# CITY OF ALBUQUERQUE

October 30, 2015

**RE: Abraham – Beach Property  
Drainage and Grading Plan  
Engineer’s Stamp Date 9-14-15 (File: F16D003E1)**

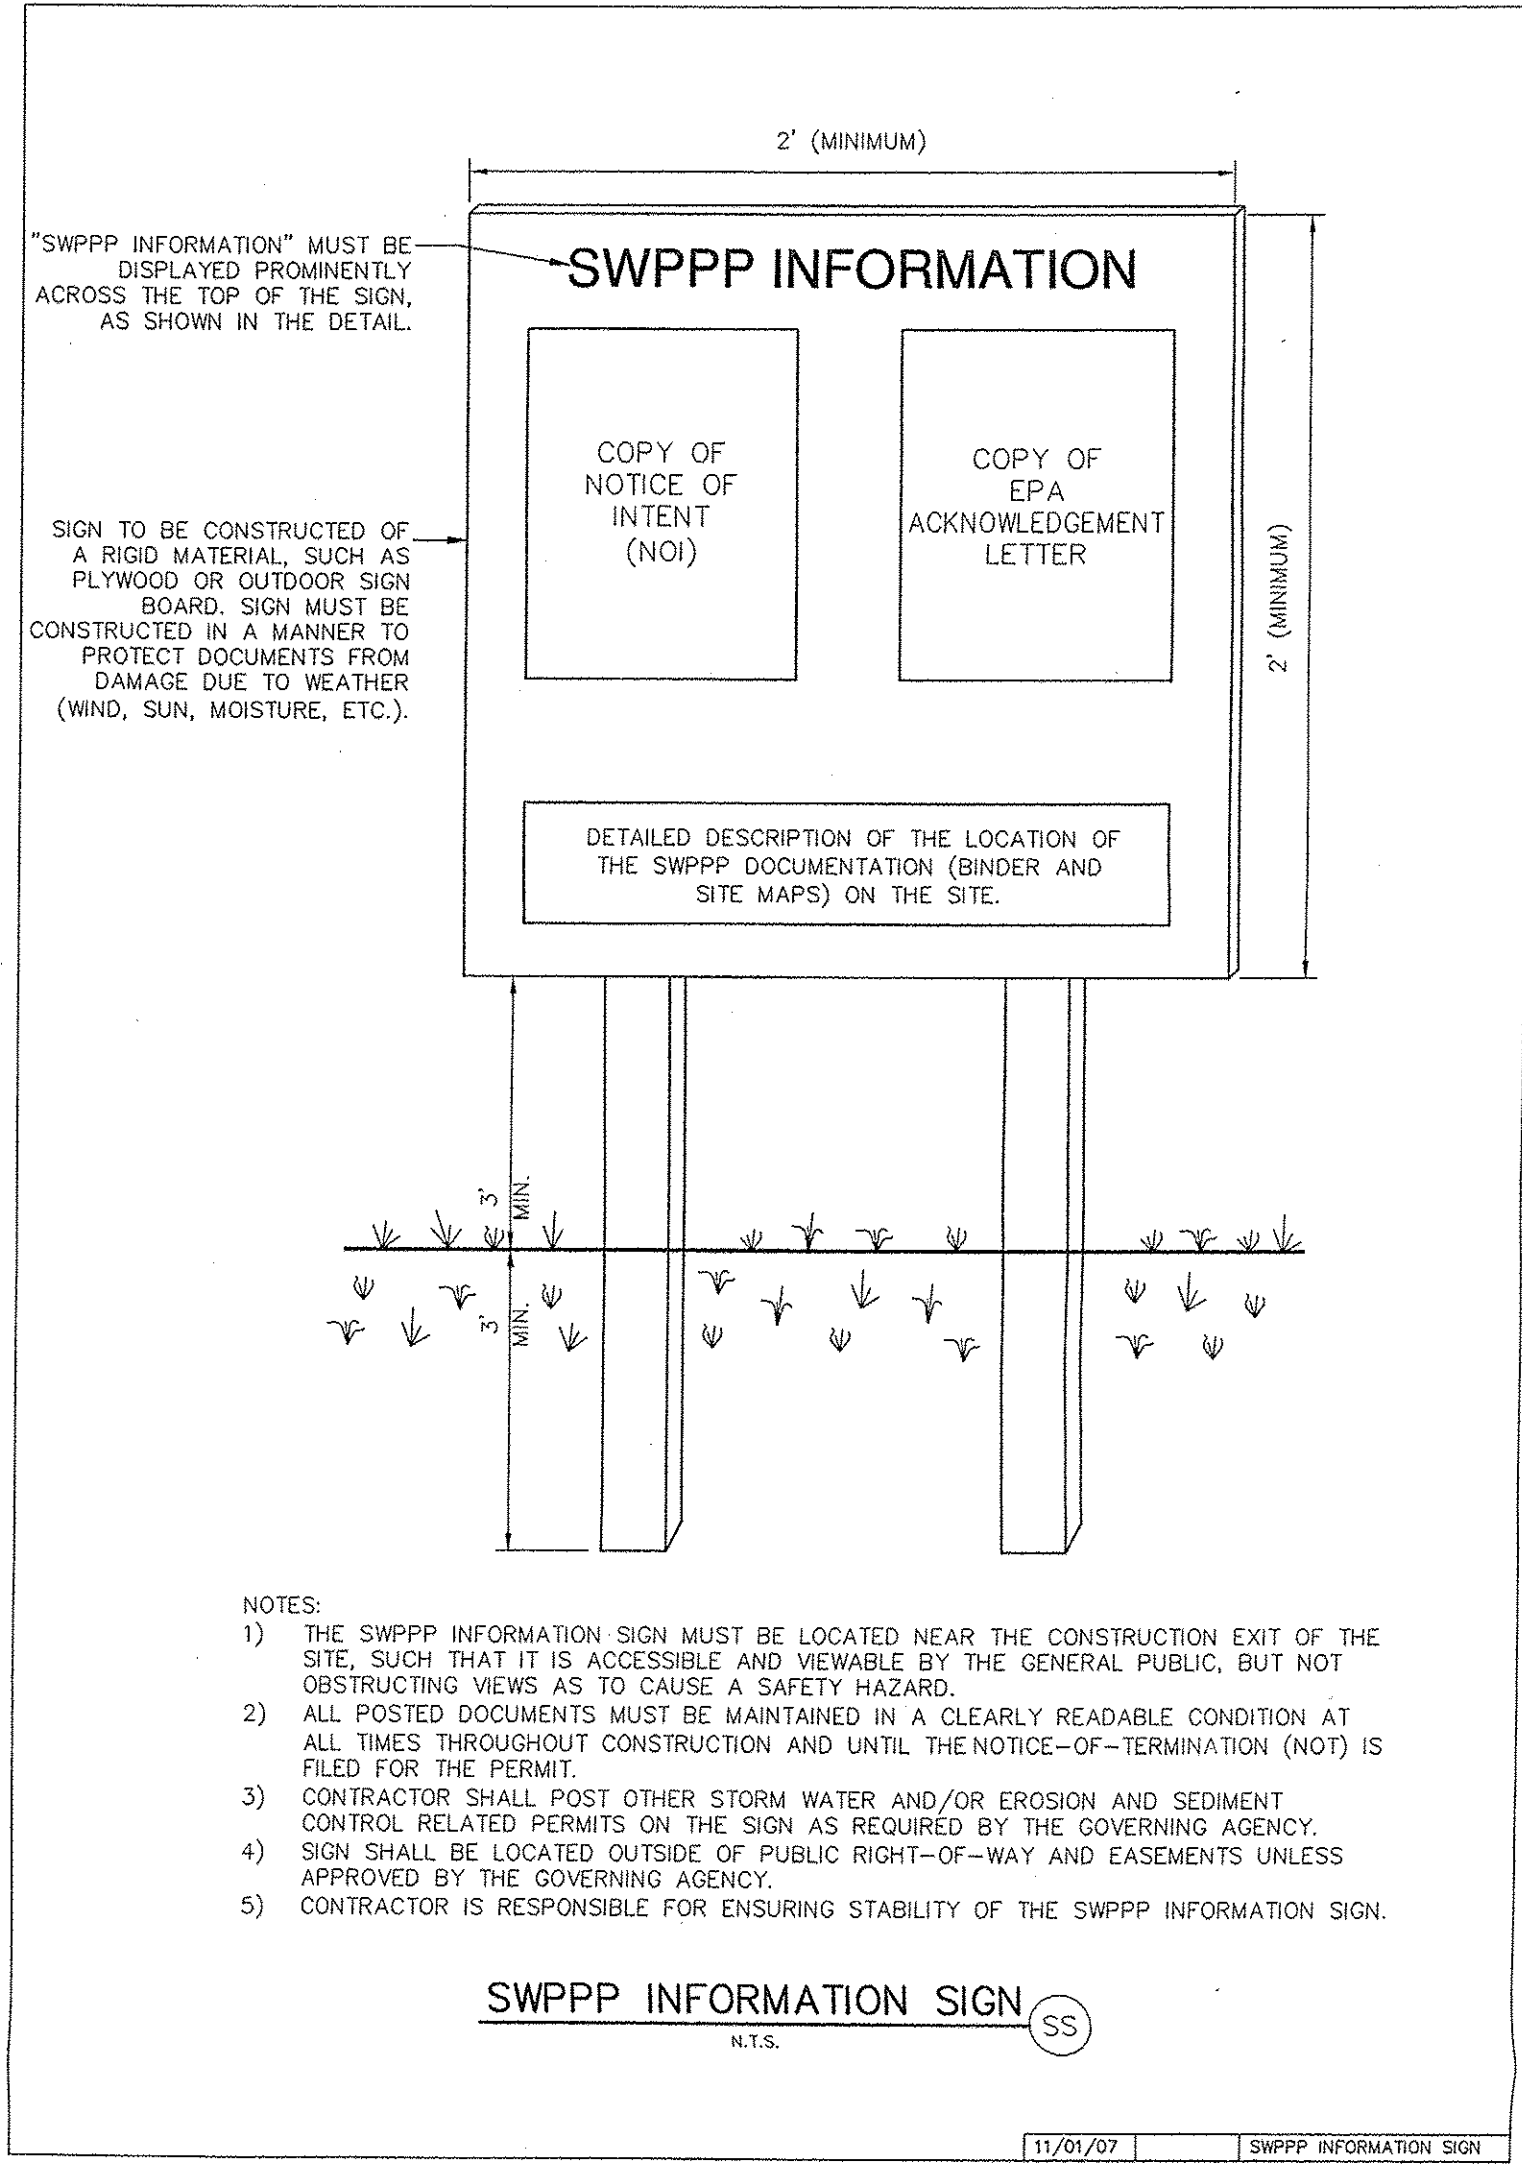
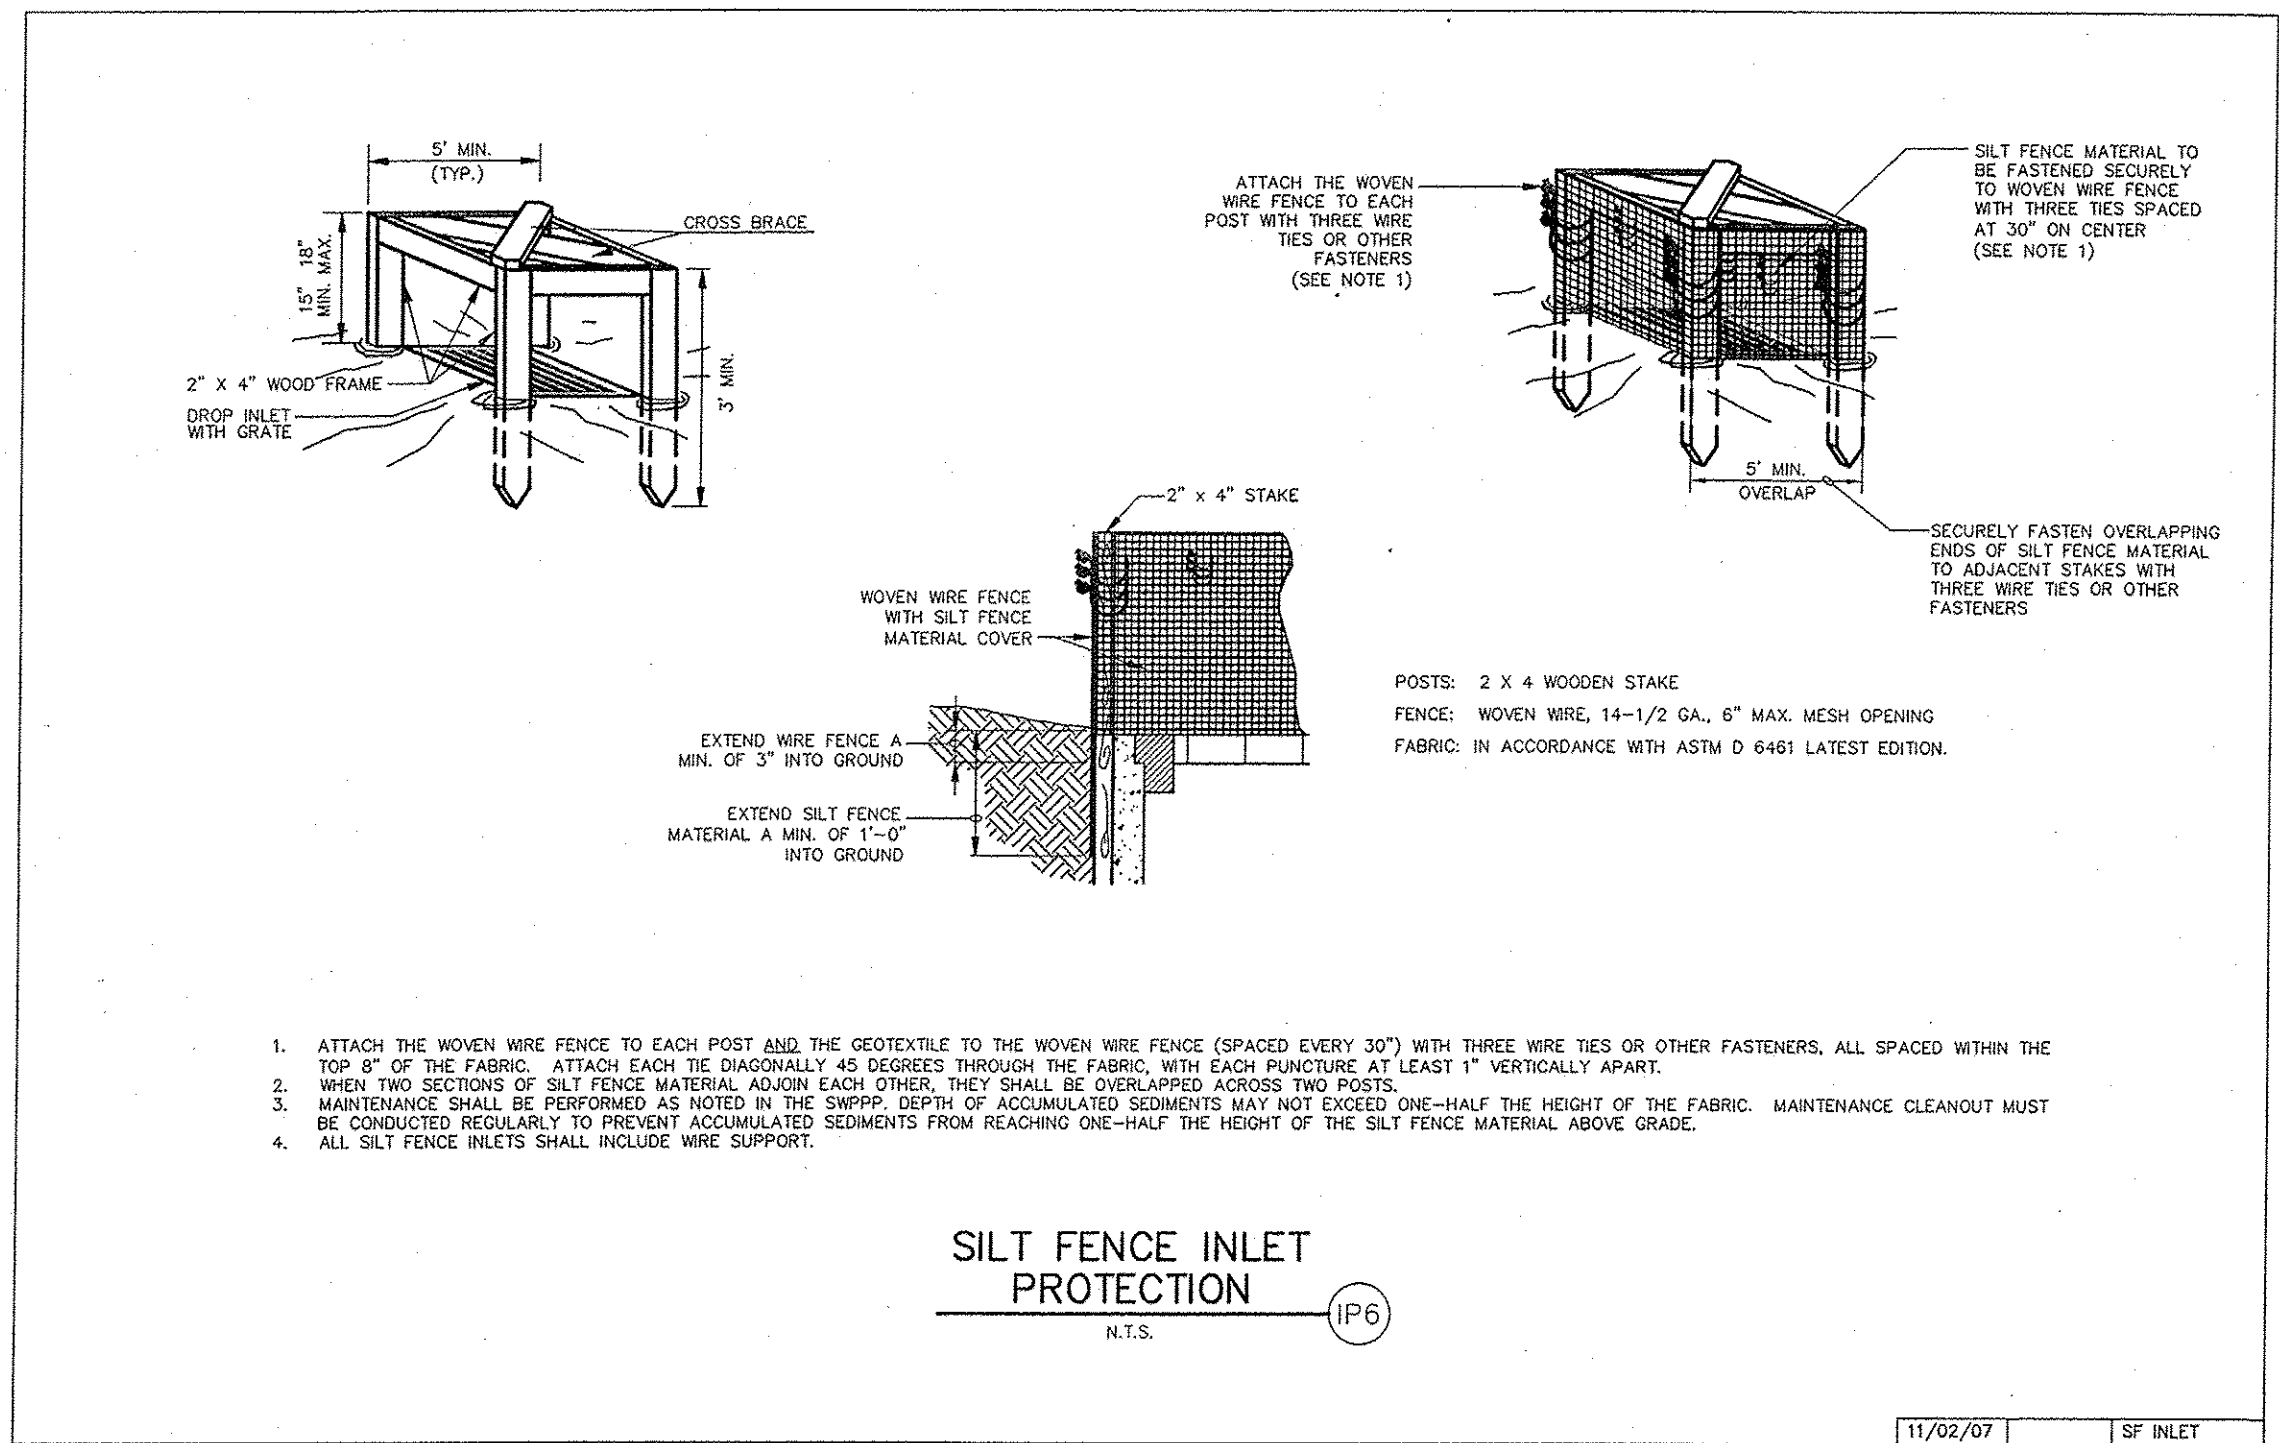
- The Basin Map on Sheet C2 references existing drainage that do not appear to match the proposed layout. Correct the Existing Drainage Condition language to reflect the fact that Basins 1 and 3 do not drain to the detention pond.

- The Proposed Drainage Condition language on Sheet C2 does not seem to be associated with this project (e.g., references to the “Frito Lay pond” and mismatched Basin numbers).

- The Northeast corner of the pond is graded in a manner that encroaches into the access aisle of the parking lot of Basin 7.
- Basin 9 quantified in the calculations appears to refer to the Shell/McDonald’s/Starbucks development. It should be labeled on the Basin Map.
